An
Coimisiún
Pleanála

Record of 2nd Meeting ABP-323038-25

Case Reference / Description	Proposed Development of 24 no. wind turbines, associated hardstands, electrical cabling, site development works, and an onsite 110kV substation and grid connection located in the townlands of Ballyguiry, Carronadavderg, Carronahyla, Carronbeg and others in County Waterford		
Case Type	Pre-application consultation		
1st / 2nd / 3rd / 4th Meeting	2 nd Meeting		
Date	24/02/2026	Start Time	11:30am
Location	Virtually	End Time	1:00pm

Stage 1 & 2 Freshwater Pearl Mussel (FPM) surveys

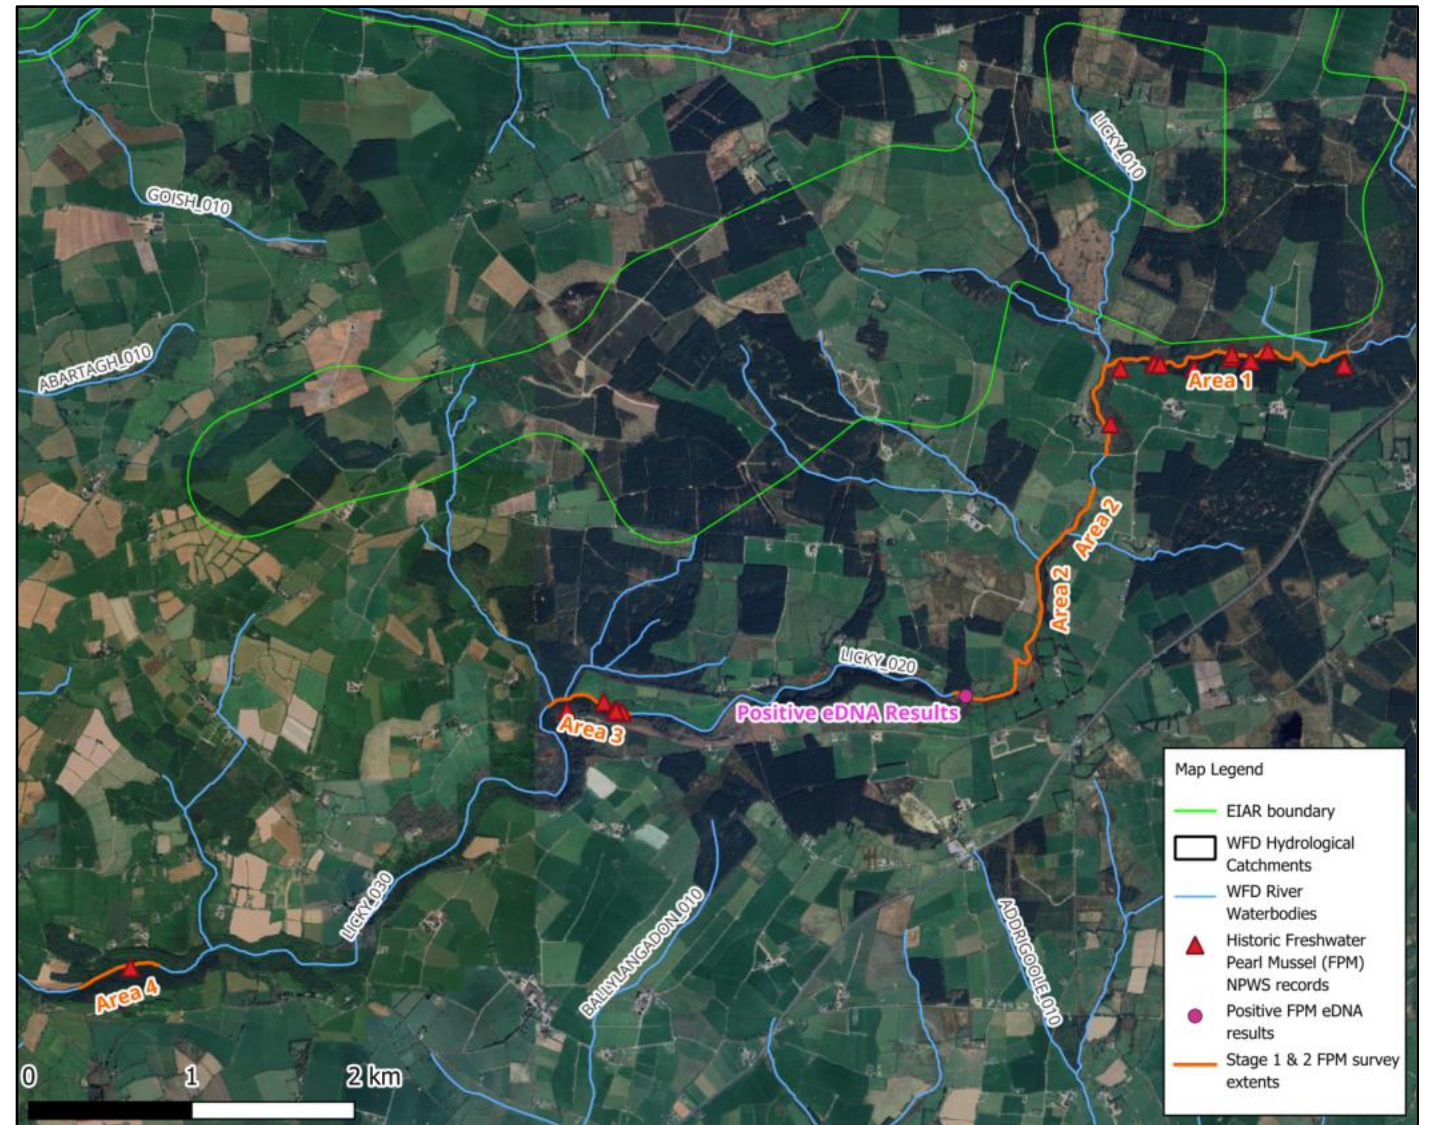
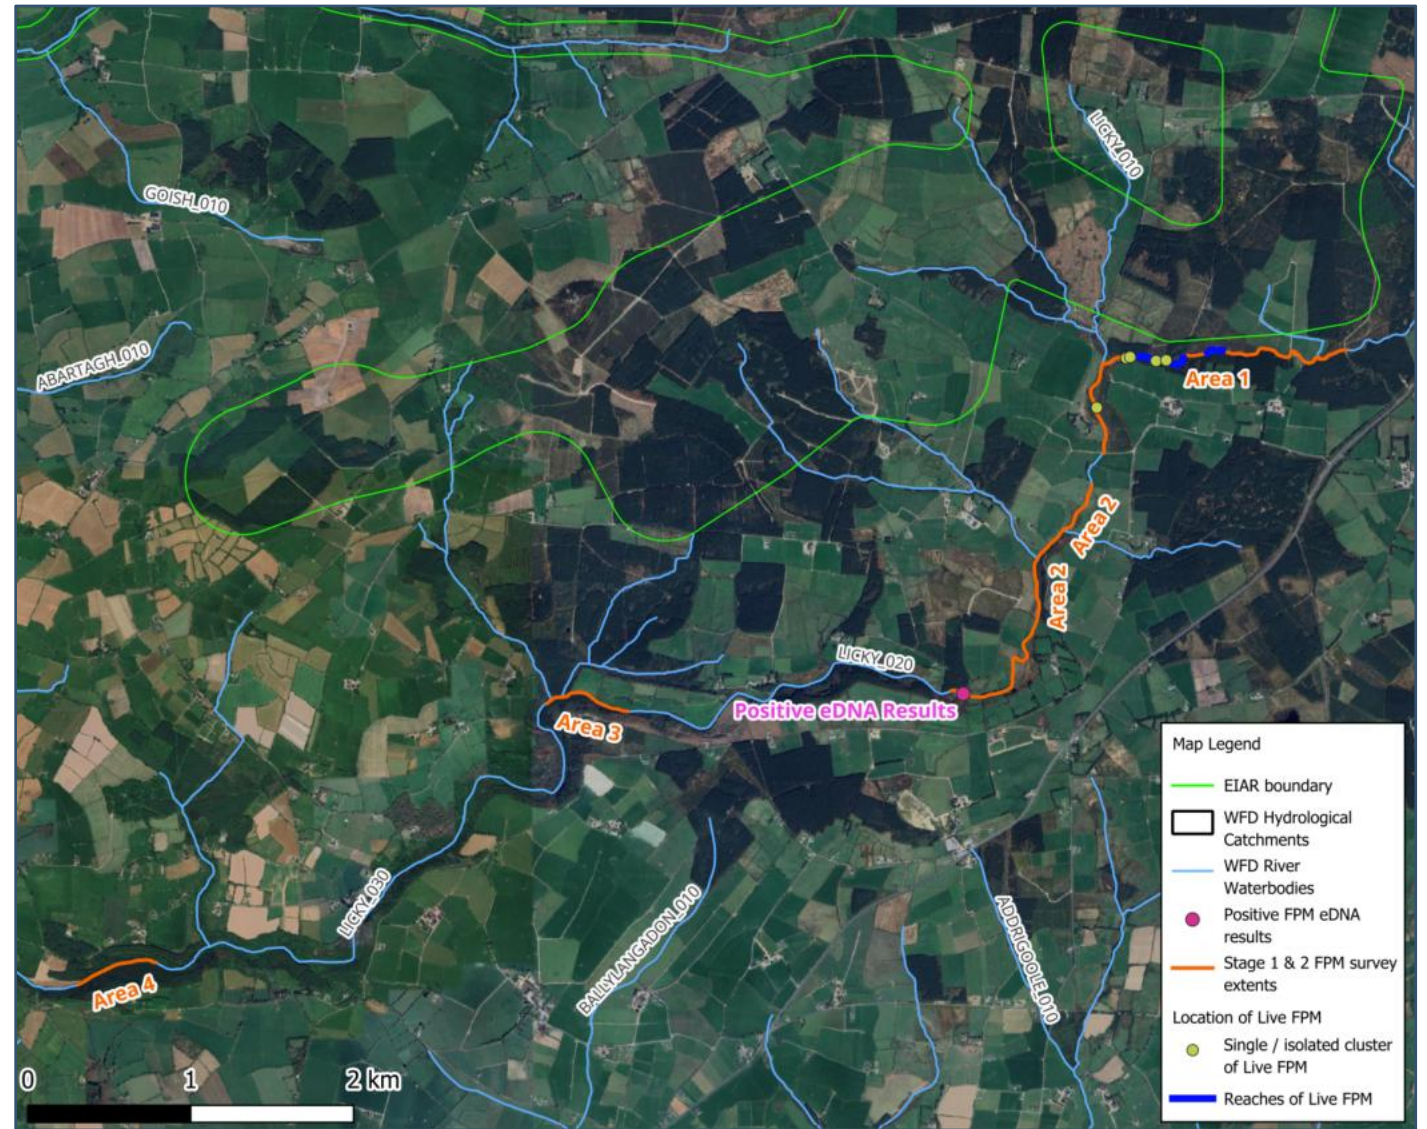
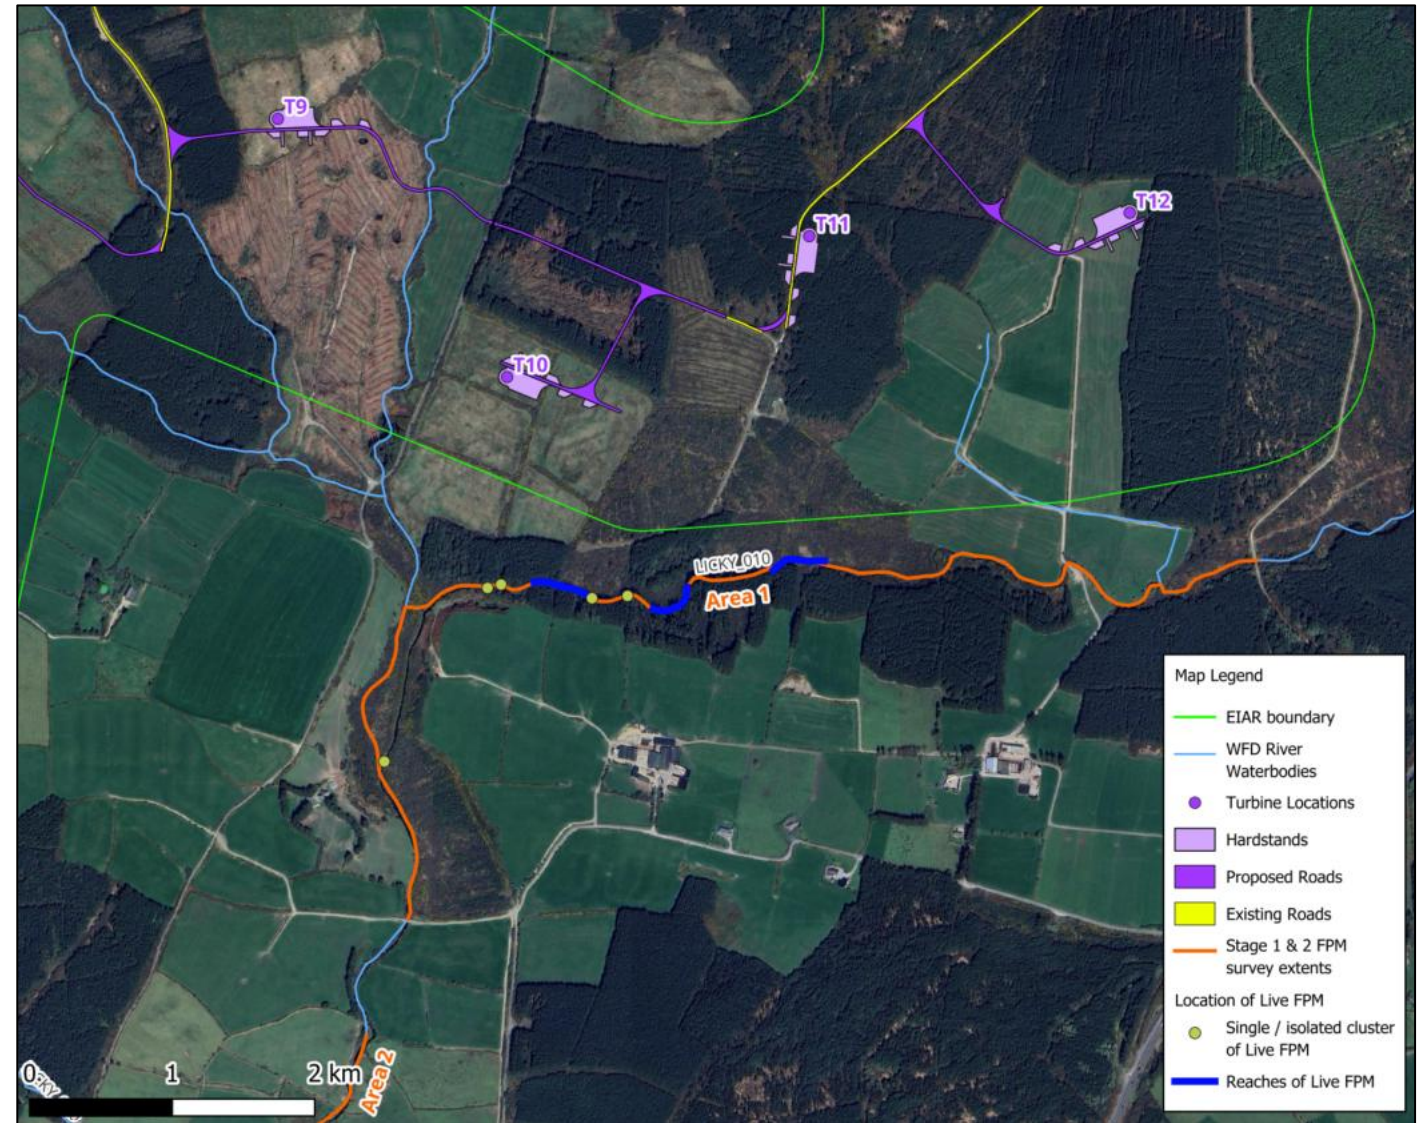
- Commission's representatives advised of the need to provide a robust evidence-based assessment on potential impacts on Freshwater Pearl Mussel (*Margaritifera margaritifera*), a critically endangered species highly sensitive to siltation, nutrient enrichment, and hydrological changes, which requires integrated coordination between the Prospective Applicants' ecologists, hydrologists and engineers. Commission's representatives advised that the assessment has regard to relevant site-specific conservation objectives (SSCOs) and up to date regulatory guidance.

- Prospective applicant outlined that baseline aquatic ecology surveys will be completed upstream and downstream of the proposed river crossings. The results will be used to characterise existing conditions and to inform the scope and design of ecological monitoring during the construction phase.

Hydrology & Hydrogeology, Geology & Soils

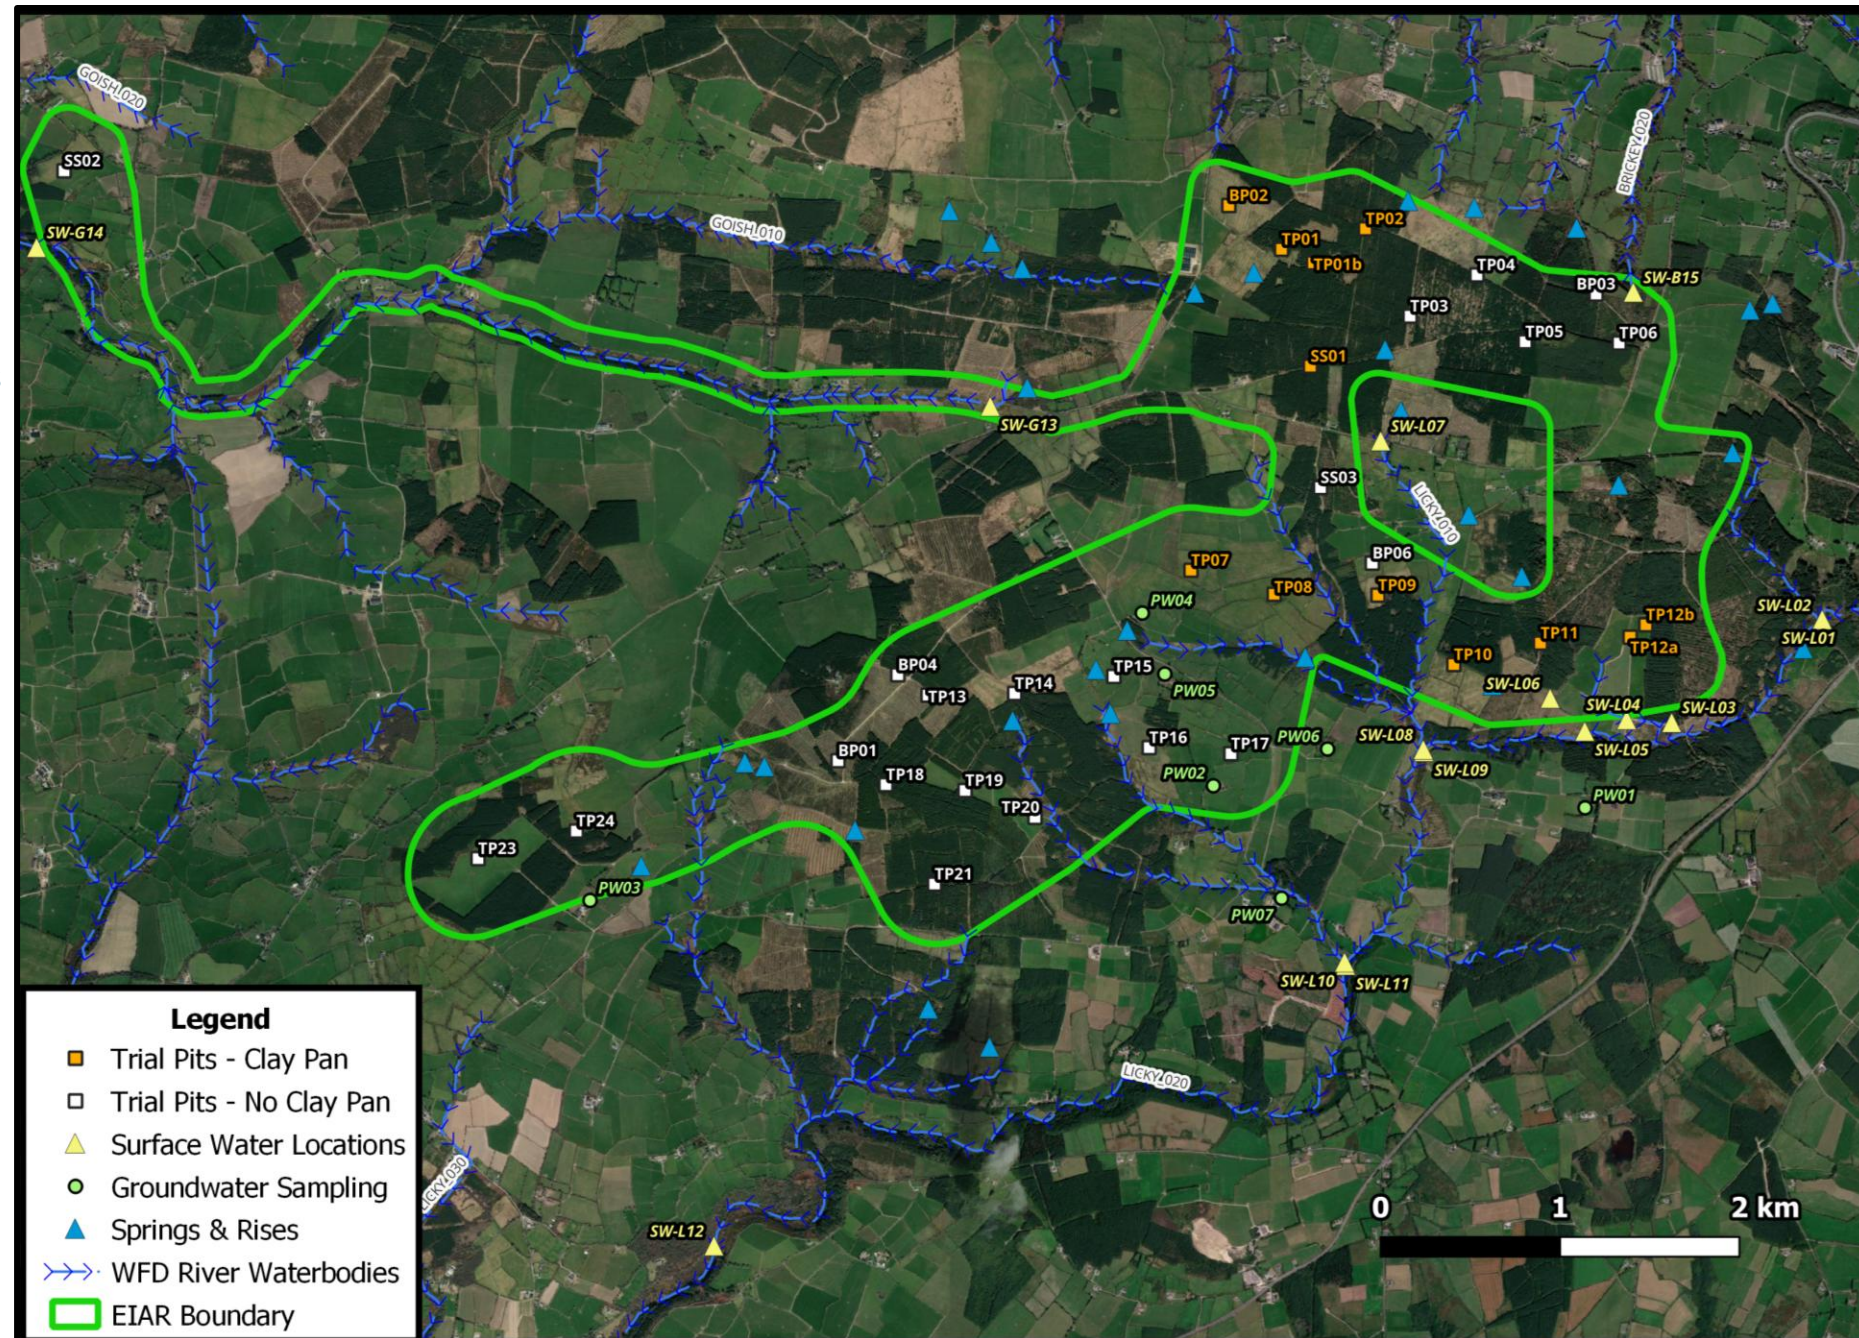
- Commission's representatives queried the proposal to remove the clay pan and rerouting of the drains in areas of construction and potential for alteration to ground water flow patterns across the site and how this could infringe on hydrology features across the site.

- Prospective applicant outlined that there are springs and flushes in the west of the area. Clay pan (impermeable layer) was observed close to Borrow pit 1.

- Regarding the borrow pits and the potential elevated groundwaters and groundwaters, the Commission's representatives queried what kind of water management is proposed and if there be a discharge from said pits.
